Mr Kale Langford  
Project Consultant  
DOMA HOLDINGS (HONEYSUCKLE) PTY LTD  
Suite 2B, 125  
BULL STREET  
NEWCASTLE WEST New South Wales 2302  
10/02/2022

42 Honeysuckle Drive Mod 2 (SSD 10378 Mod 2)  
**Request for additional information**

I refer to the Department's assessment for the 42 Honeysuckle Drive Mod 2 (SSD 10378 Mod 2). We require additional information regarding the proposed changes to building methodology and façade treatment of the hotel building.

South Elevation

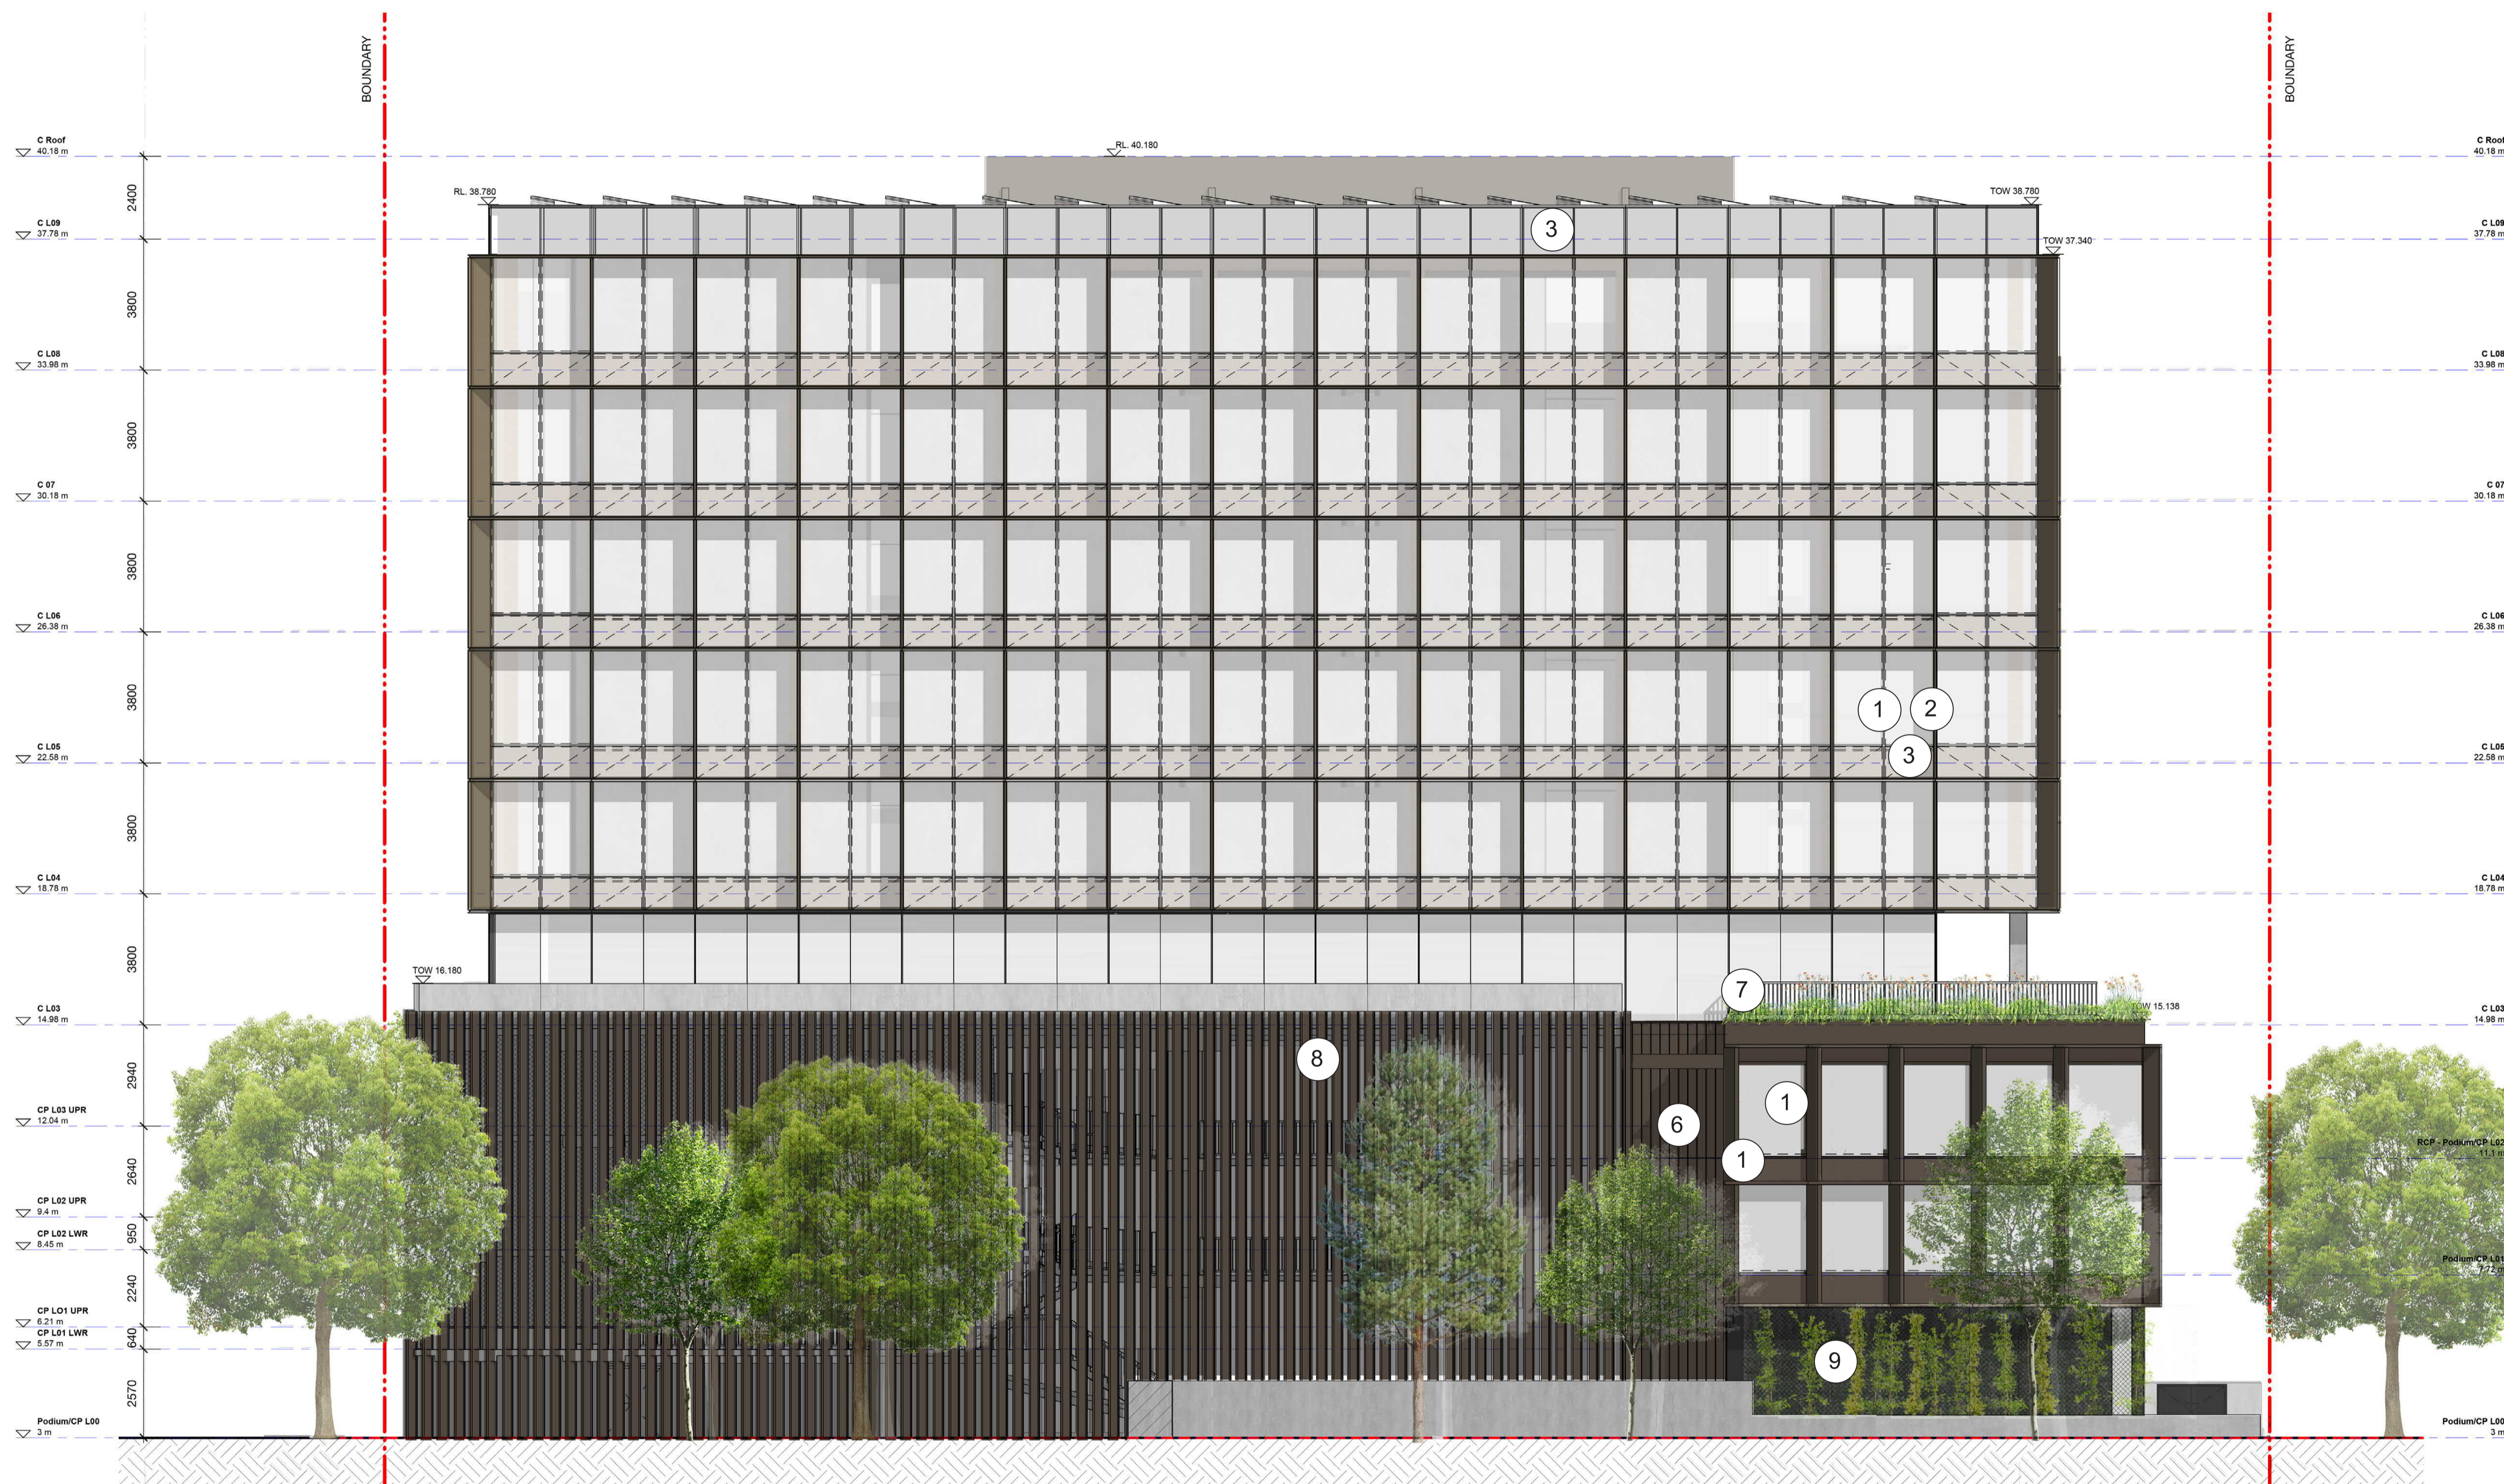
- elevations that clearly show the proposed façade changes and the materials and finishes (similar to those provided in Appendix B of this modification which show the approved elevations). The elevations currently provided of the proposed changes are predominantly in grey and the proposed changes to façade are not clear, and
- additional description of the proposed change in construction methodology and any impacts associated with this change.
